RE: Monterey Baptist Church
12501 Lomas Blvd NE
Request Permanent C.O. - Approved
Engineers Stamp Date 6/17/15 (J22D012A)
Certification date: 3-16-16

**RE: Monterey Baptist Church
12501 Lomas Blvd NE
Request 90-Day Temporary C.O. - Approved
Engineers Stamp Date 6/17/15 (J22D012A)**

**RE: Monterey Baptist Church
12501 Lomas Blvd NE
Grading and Drainage Plan
Engineers Stamp Date 6/17/15 (J22D012A)**

COBBLE SWALE DETAIL

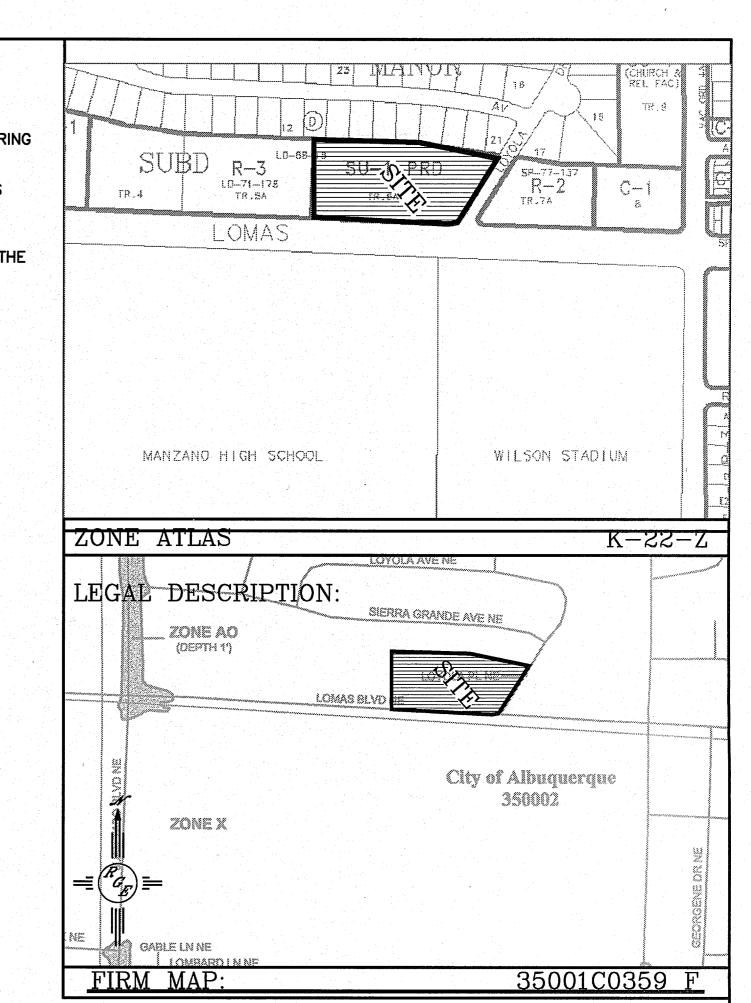
- A portion of the existing cobble swale that connects to the new pond has been removed and is missing.

Existing cobble swale that drains to pond, see sheet 2

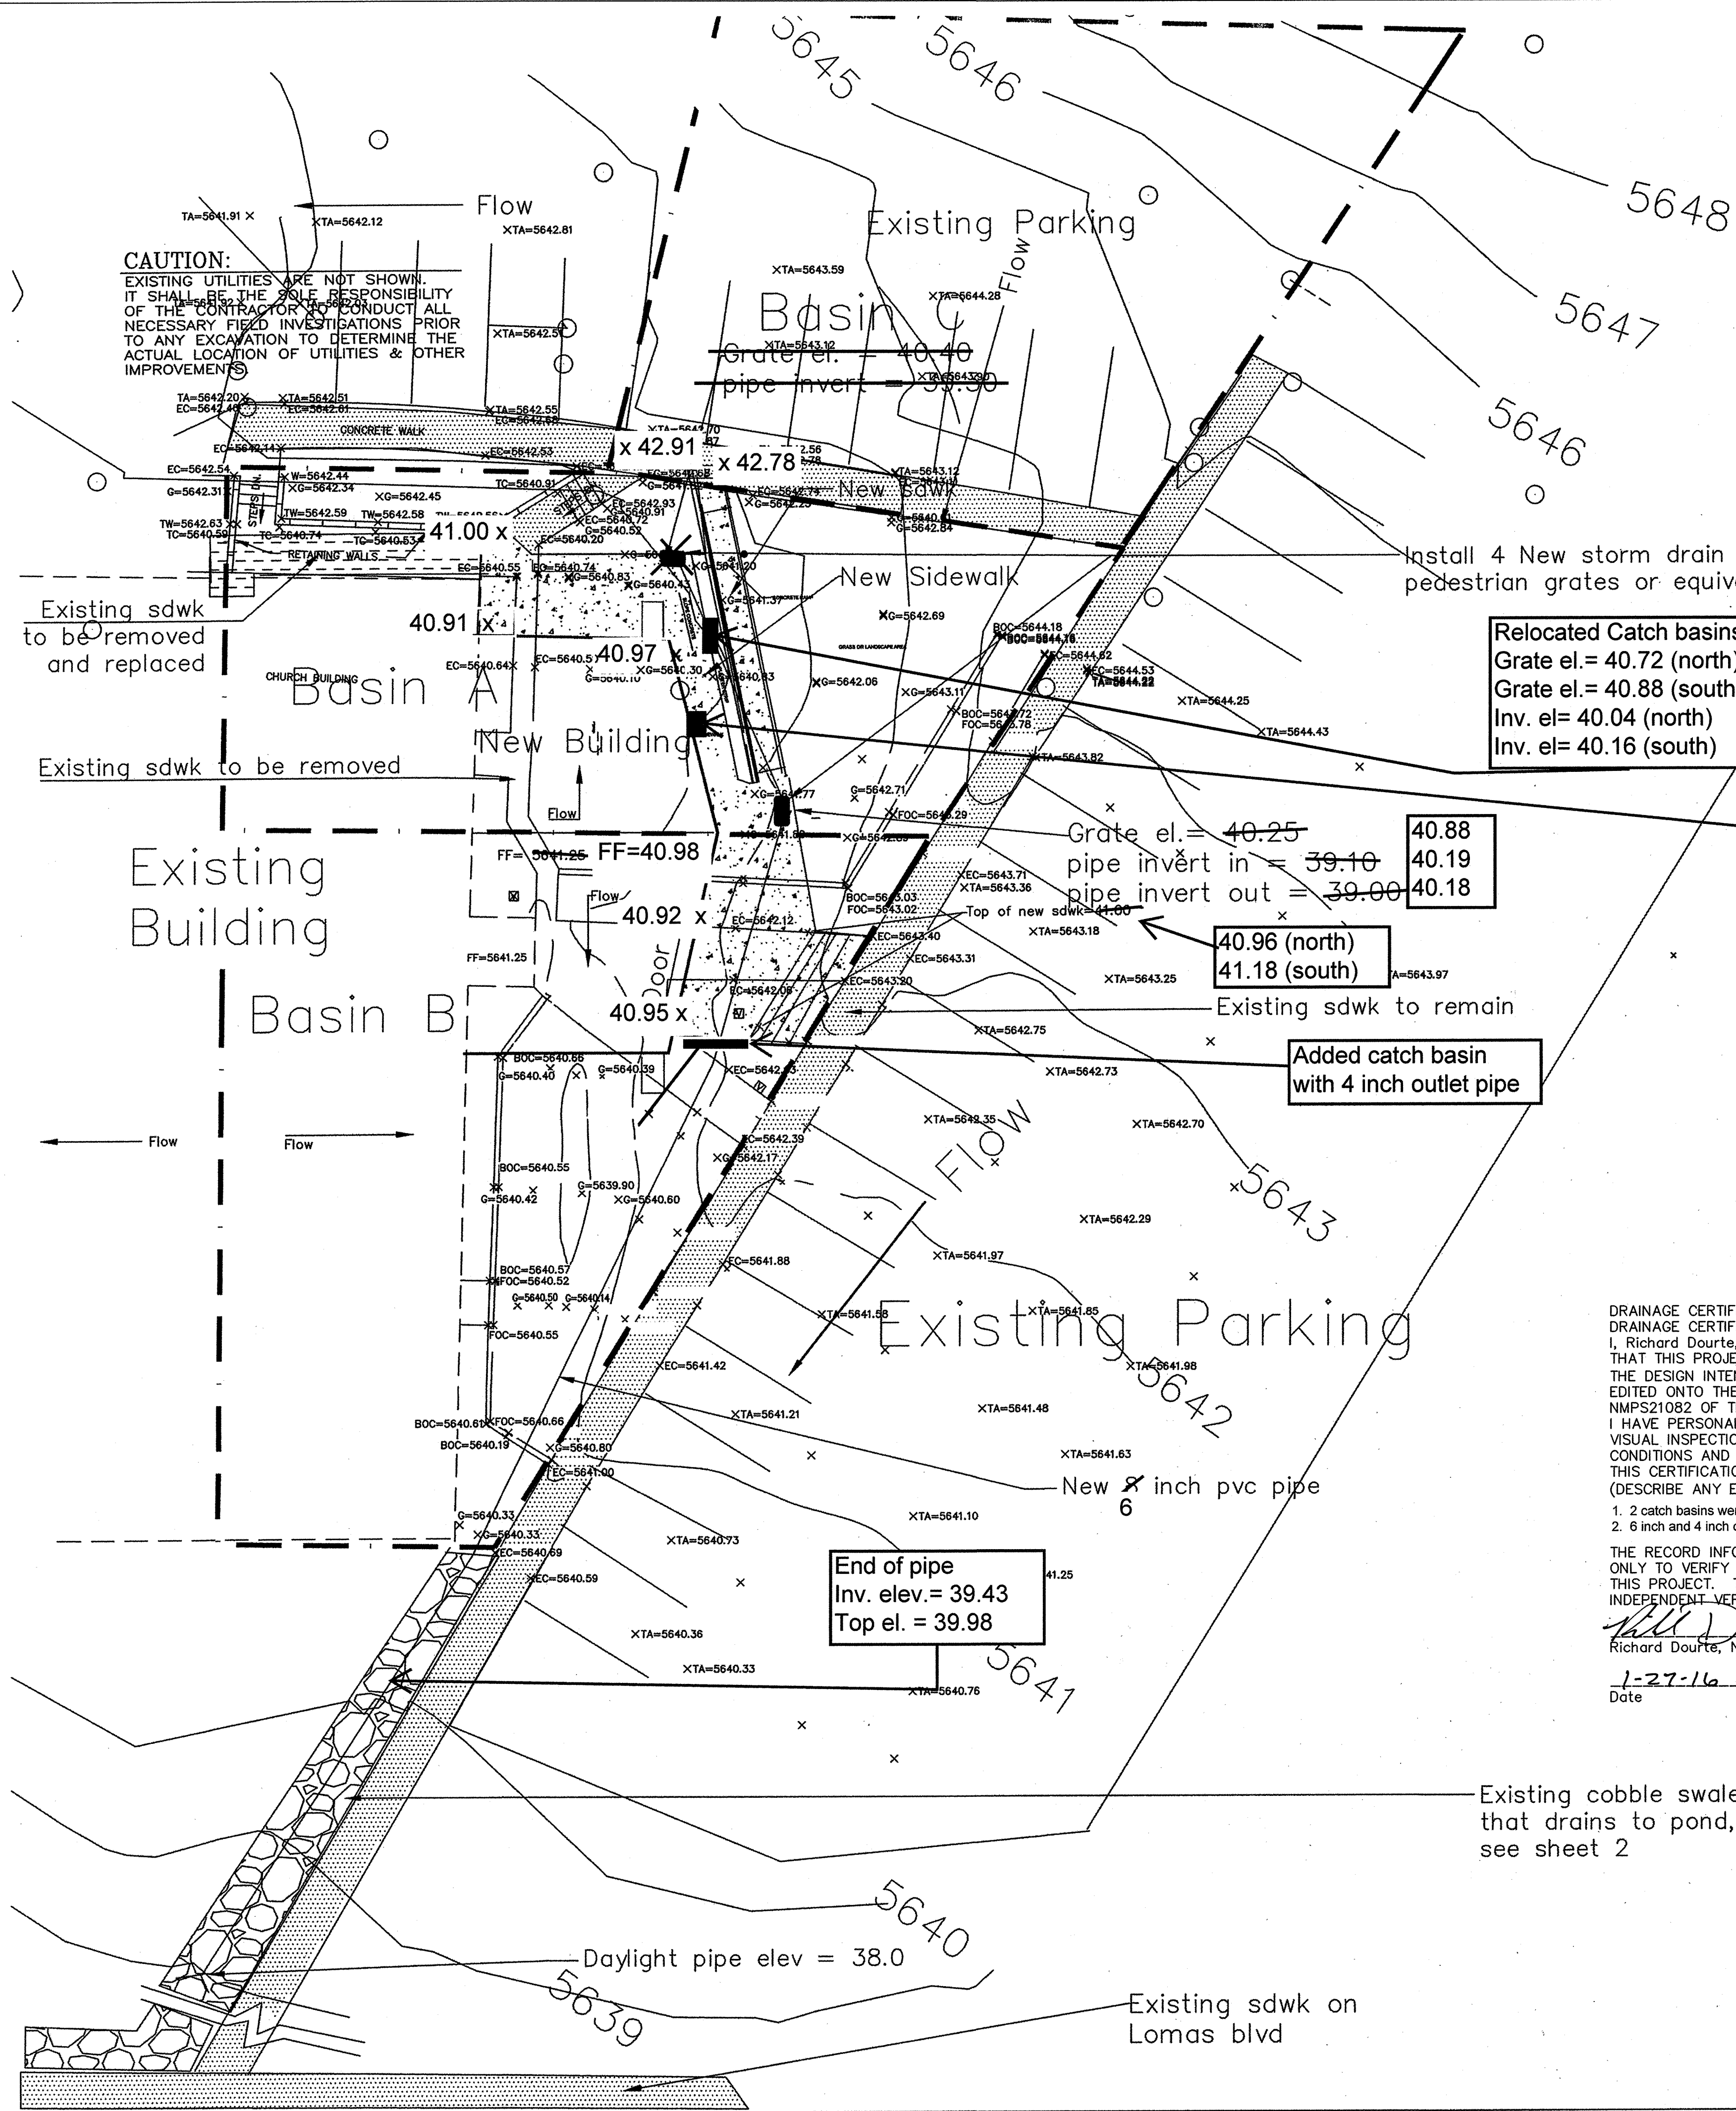
- A portion of the existing cobble swale that connects to the new pond has been removed and is missing.

Please issue a temp. CO for this building until the swale has been lined and stone has been placed. Some regrading of the swale entrance to the pond may be needed...
